**Project Name: Rollin Ridge Final Plat**

**Project Number: SF 1922**

**Description:** Approval is requested for the Final Plat Rollin Ridge, Filing #1 Estates Subdivision with 16 residential lots and 2 tracts on an approximately 57 acre parcel. This development is located west of Highway 83 and south of Hodgen Road in Section 27, Township 11 South, Range 66 West.

DRAWING: 17084FP-RevA.DWG

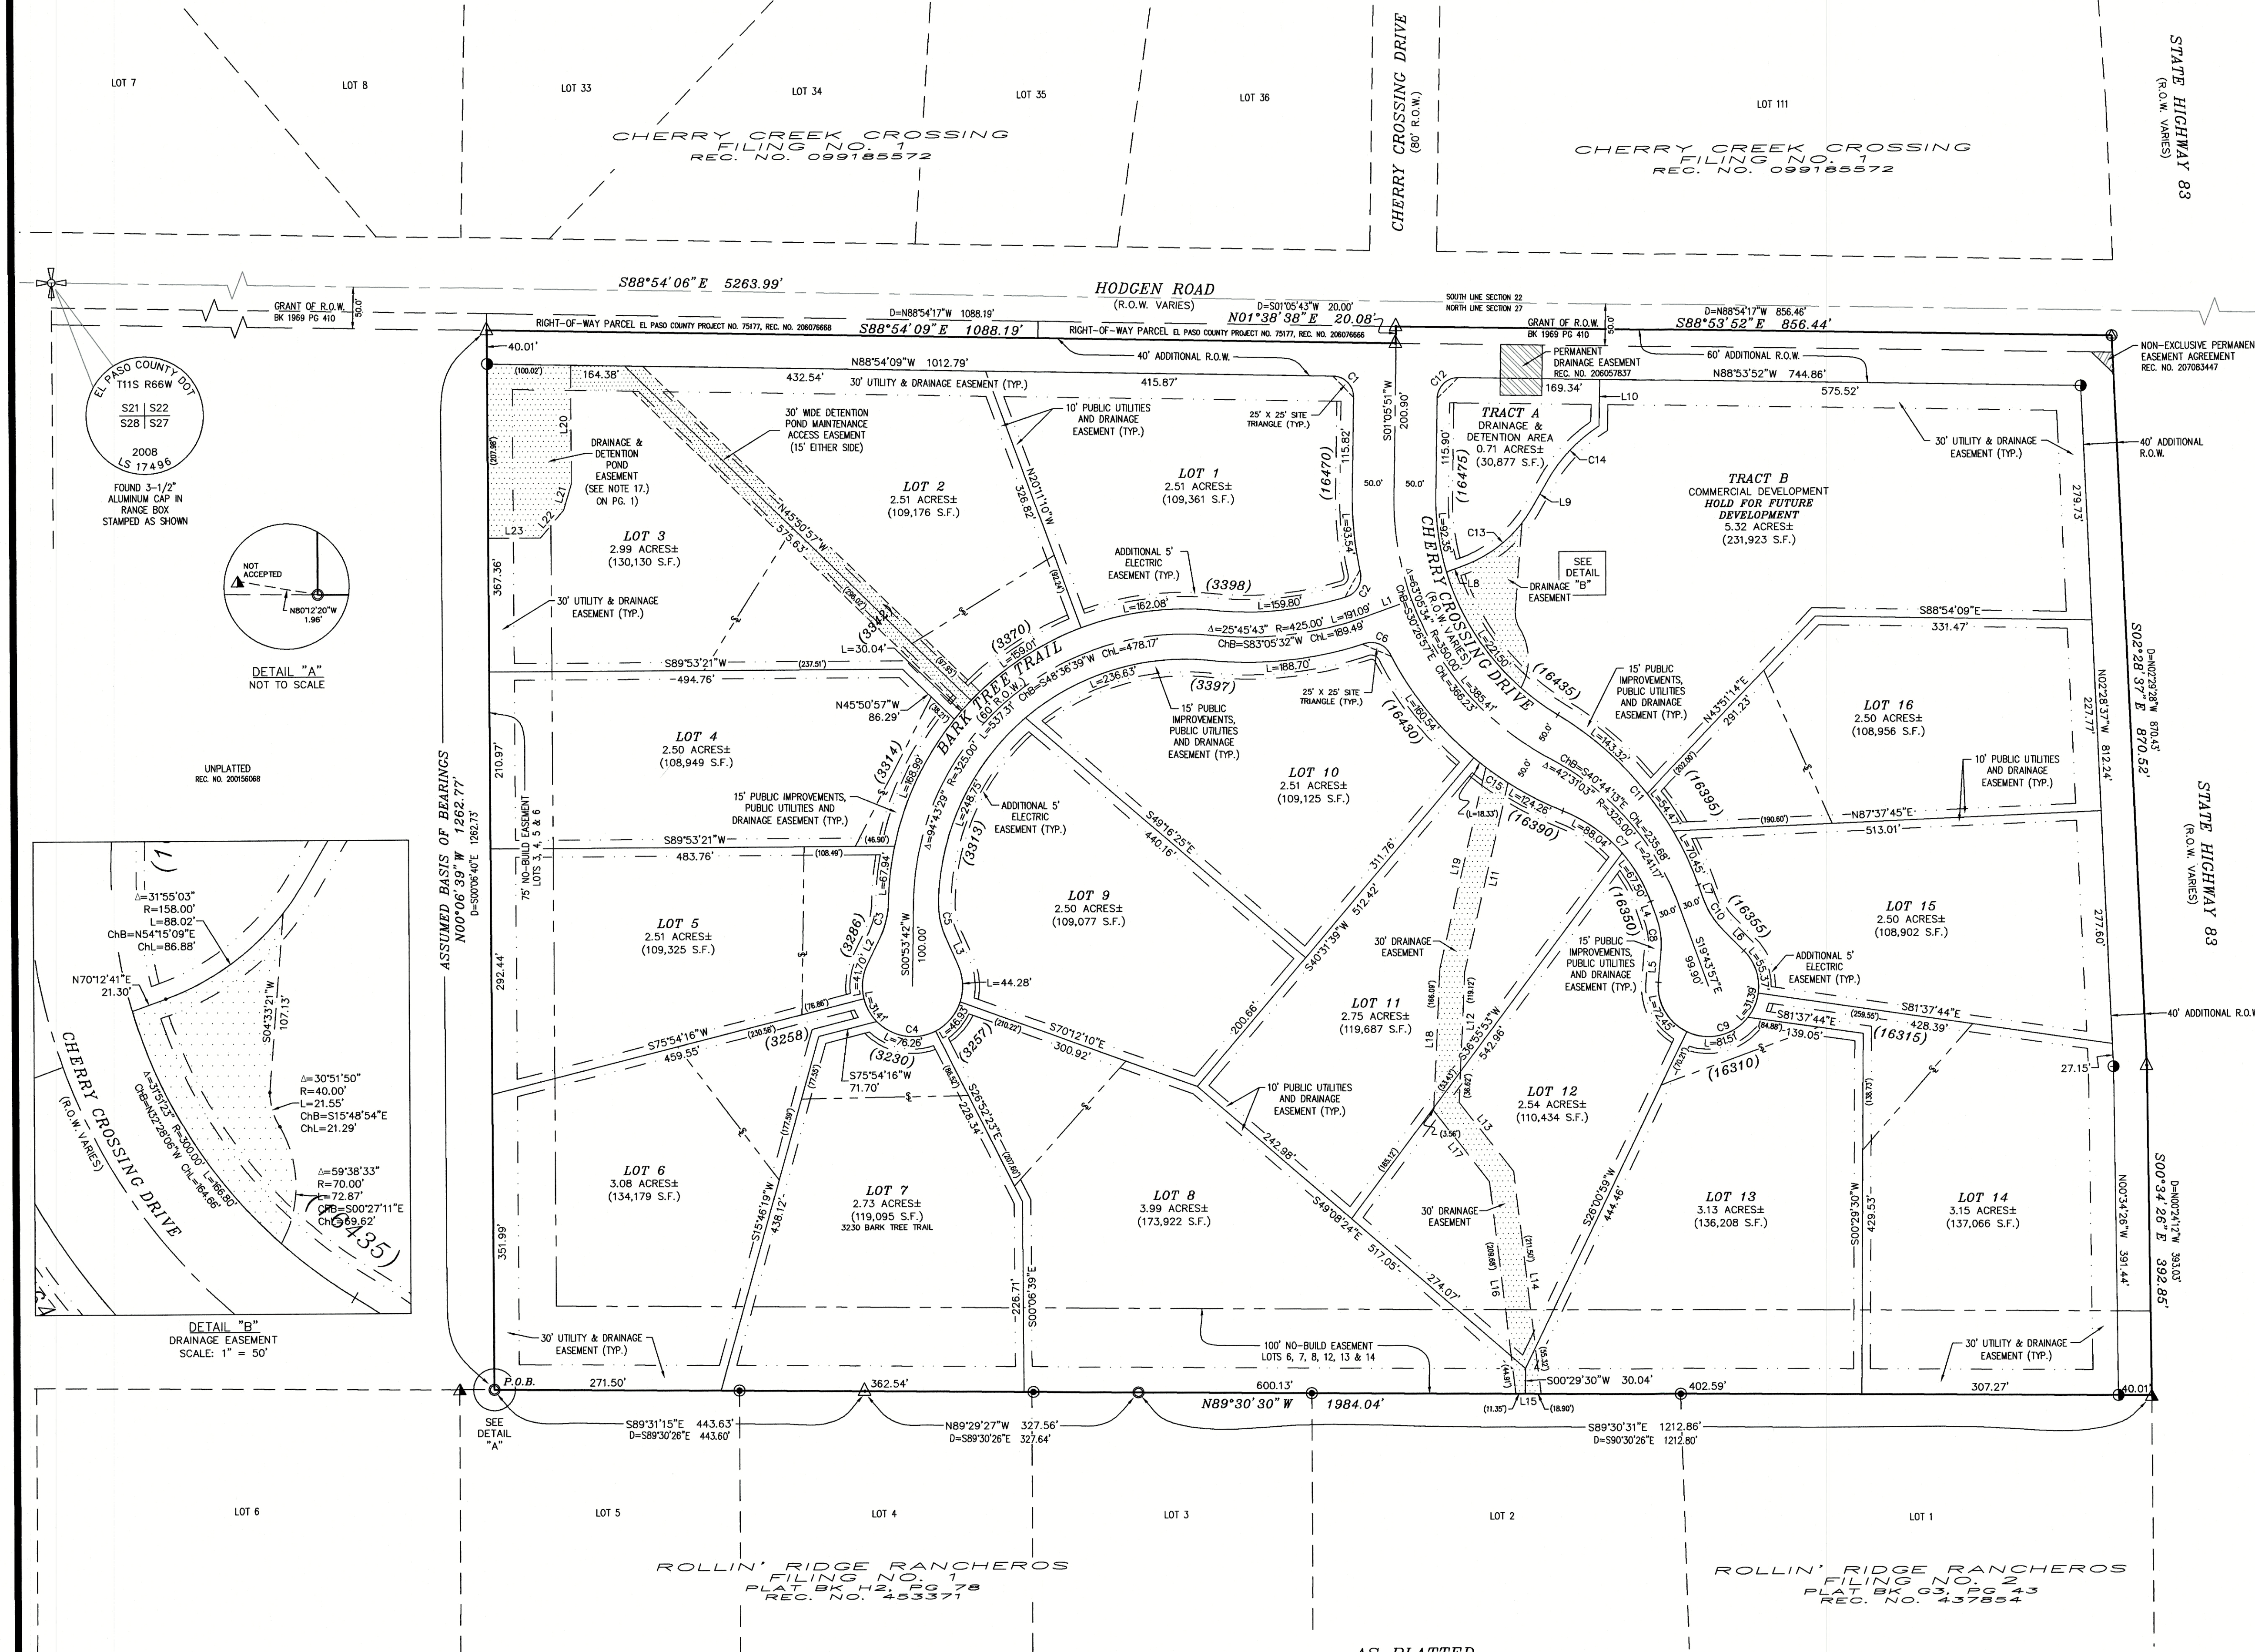
MVEA requests a ten (10) foot front side and rear lot utility easement along with a thirty (30) foot exterior easement on plat. The notes on the plat indicate the front lot line is being design with a fifteen (15) foot PU, PI and Drainage Easement. MVEA will require an additional five (5) foot utility easement be adjacent to and on the lot side of the PIE.

MVEA also requests platting of existing MVEA facilities with easement on the plat. If open space, drainage and landscape tracts are designed in this subdivision MVEA requests these areas be listed to include utilities. This will allow for design to all clusters of lots. Additional easements may be required once a review of civil drawings with grading and erosion plan is provided to MVEA in order to serve this development.
